From: Amanda Scholes on behalf of Planning.Responses
Sent: 10 October 2017 08:26
To: Planning Scanning
Subject: FW: Planning Consultation on BN/32/17/DOC

APPLICATION **BN/32/17/DOC**

Site Address: Land at former Pollards Nursery Lake Lane Bognor Regis

Description of Works: Application for approval of matters reserved by condition imposed under BN/16/12/ (APP/C3810/A/13/2193942) relating to conditions 5-surface water drainage, 6-maintenance of SUDs, 7-foul drainage system, 8-schedule of materials & finishes, 11-scheme for protection of retained trees, 13-plan indicating boundary treatments, 17-ecological enhancement measures, 18- mitigation & translocation plan for reptiles, 19- Ecological Clerk of Works for final bat checks & soft tree felling, 20-mitigation for noise sensitive facades & amenity areas, 21- pedestrian & cycle paths, 23-layout & specifications of & construction programme for roads, including access, footpaths, foul & surface water drainage & means of disposal, 25- pedestrian visibility splays & 26- Travel Plan.

Title: Engineering Layout Sheet 1 of 1

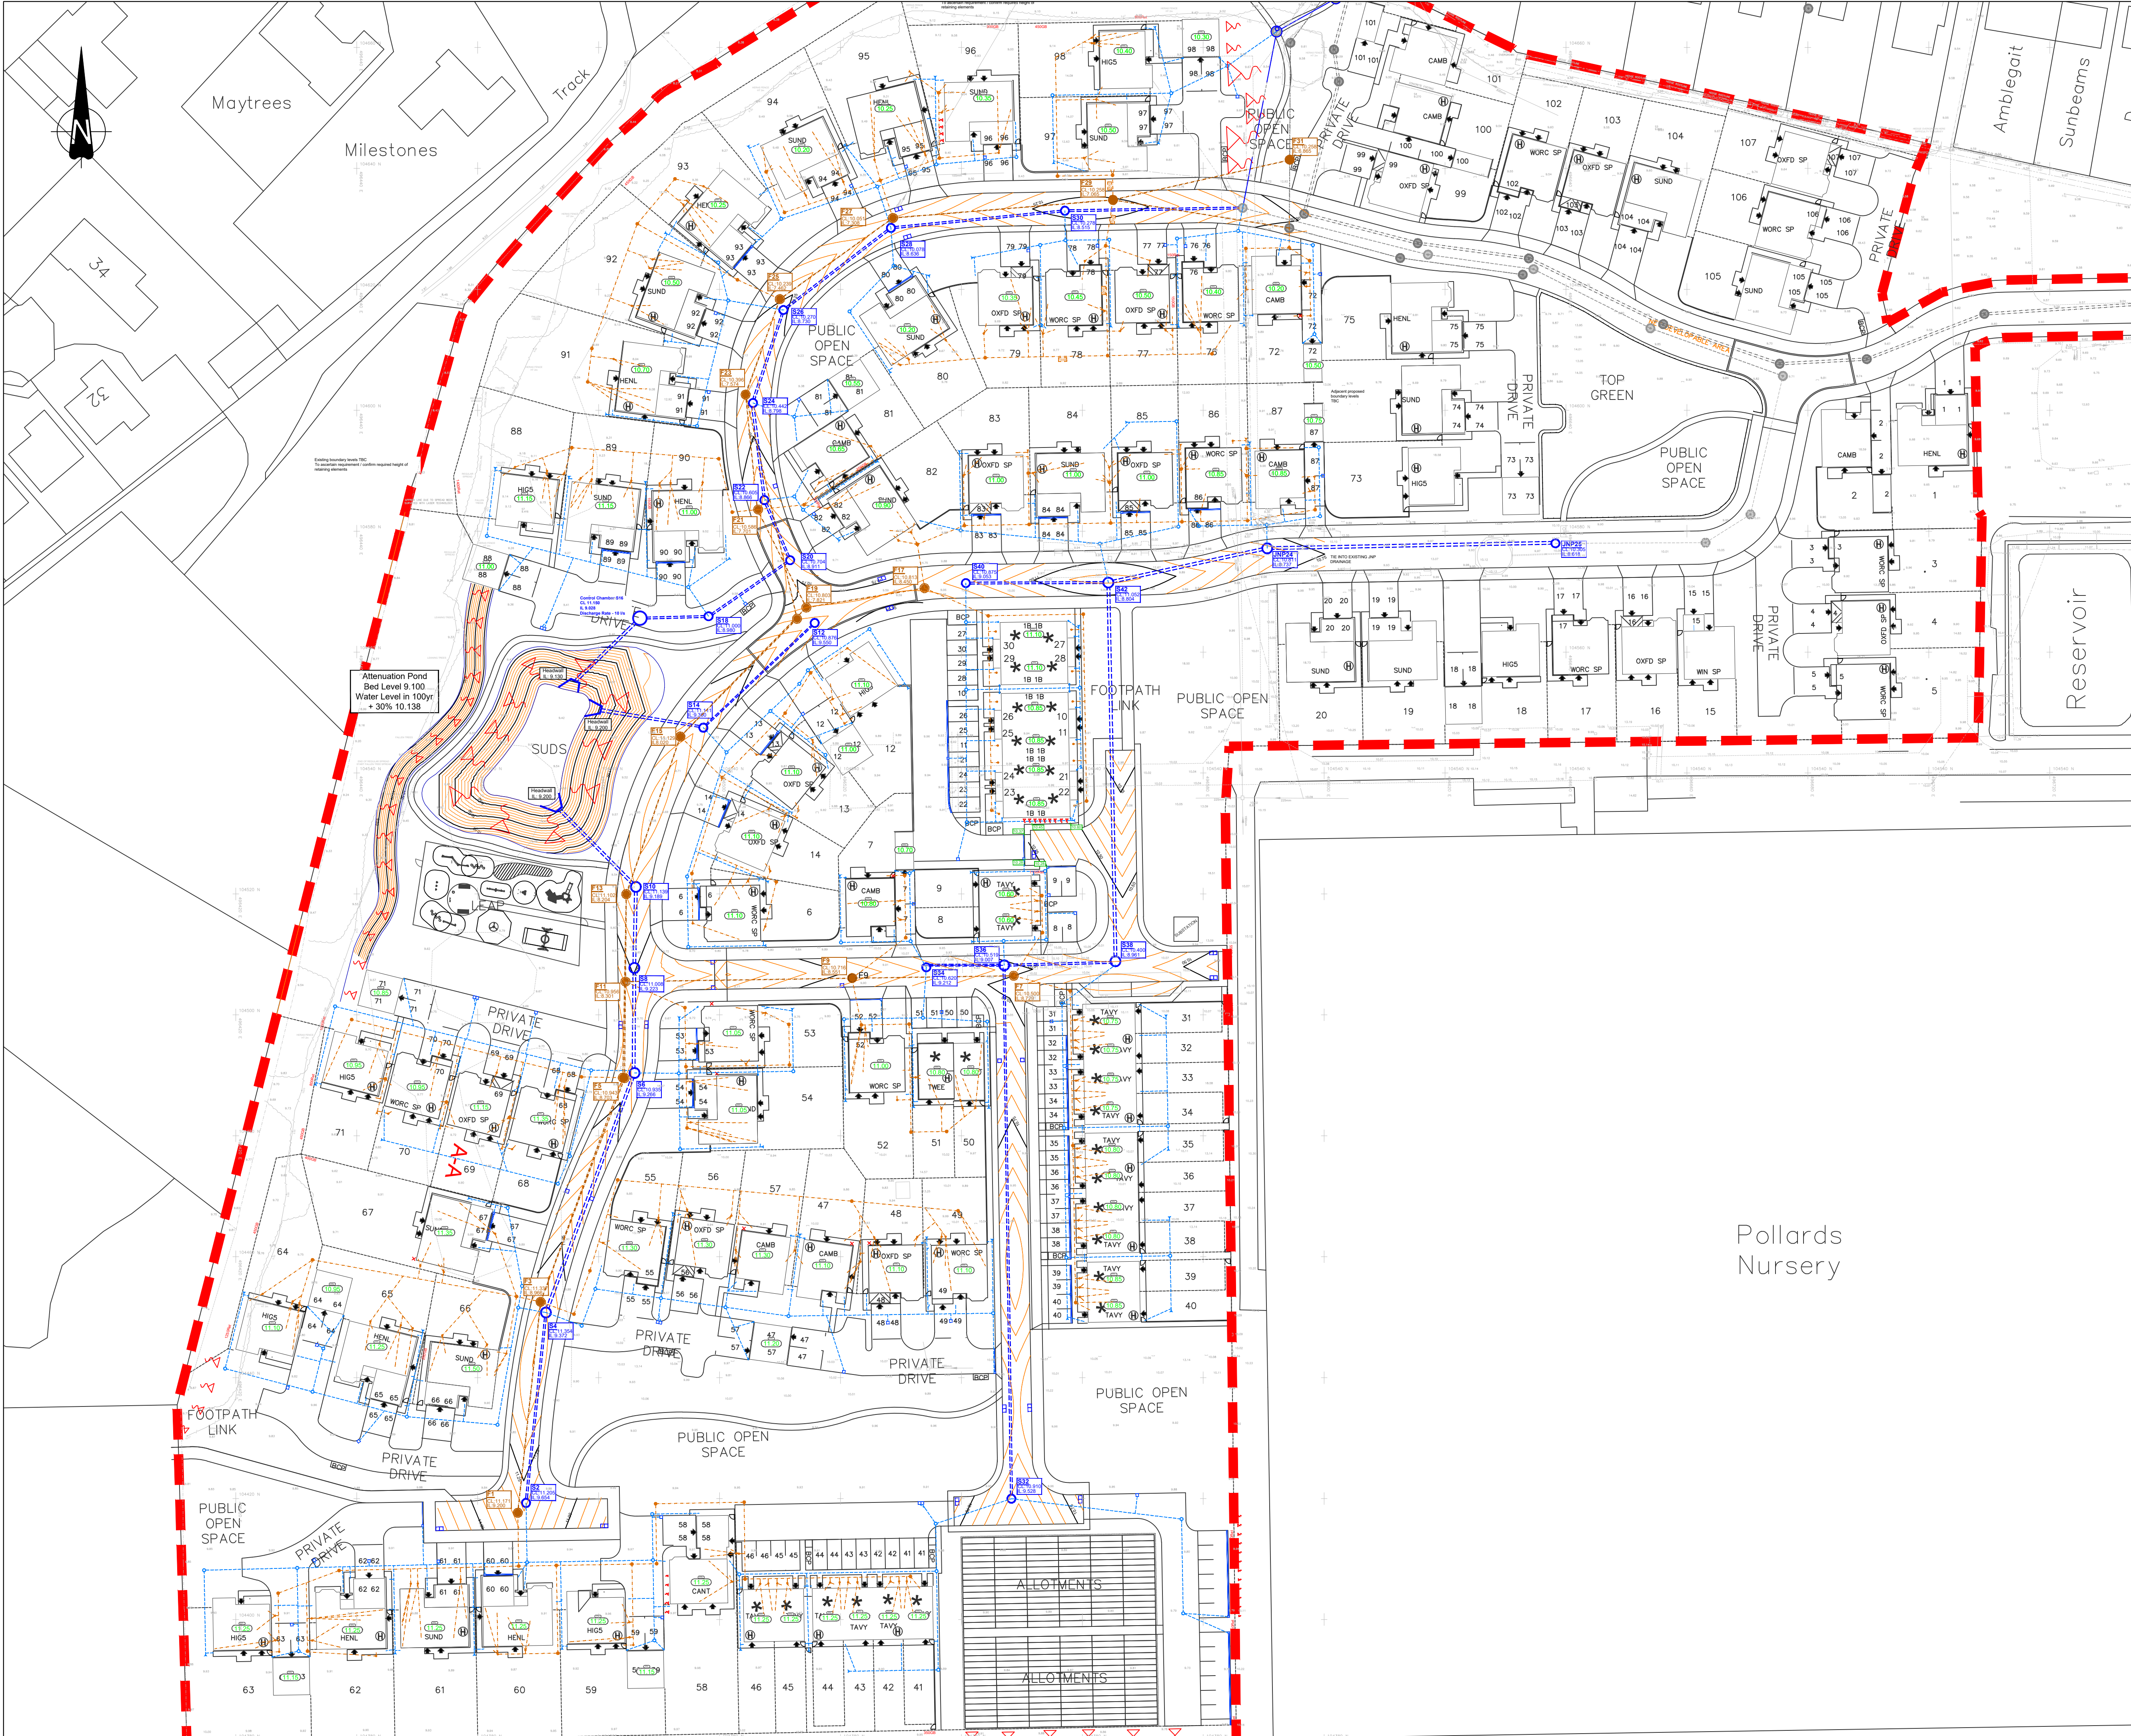
The only outstanding item is that I am awaiting proposals for the abandonment of the ditch in the north western area of the site. I emailed the consultant in this respect on the 22nd August 2017.
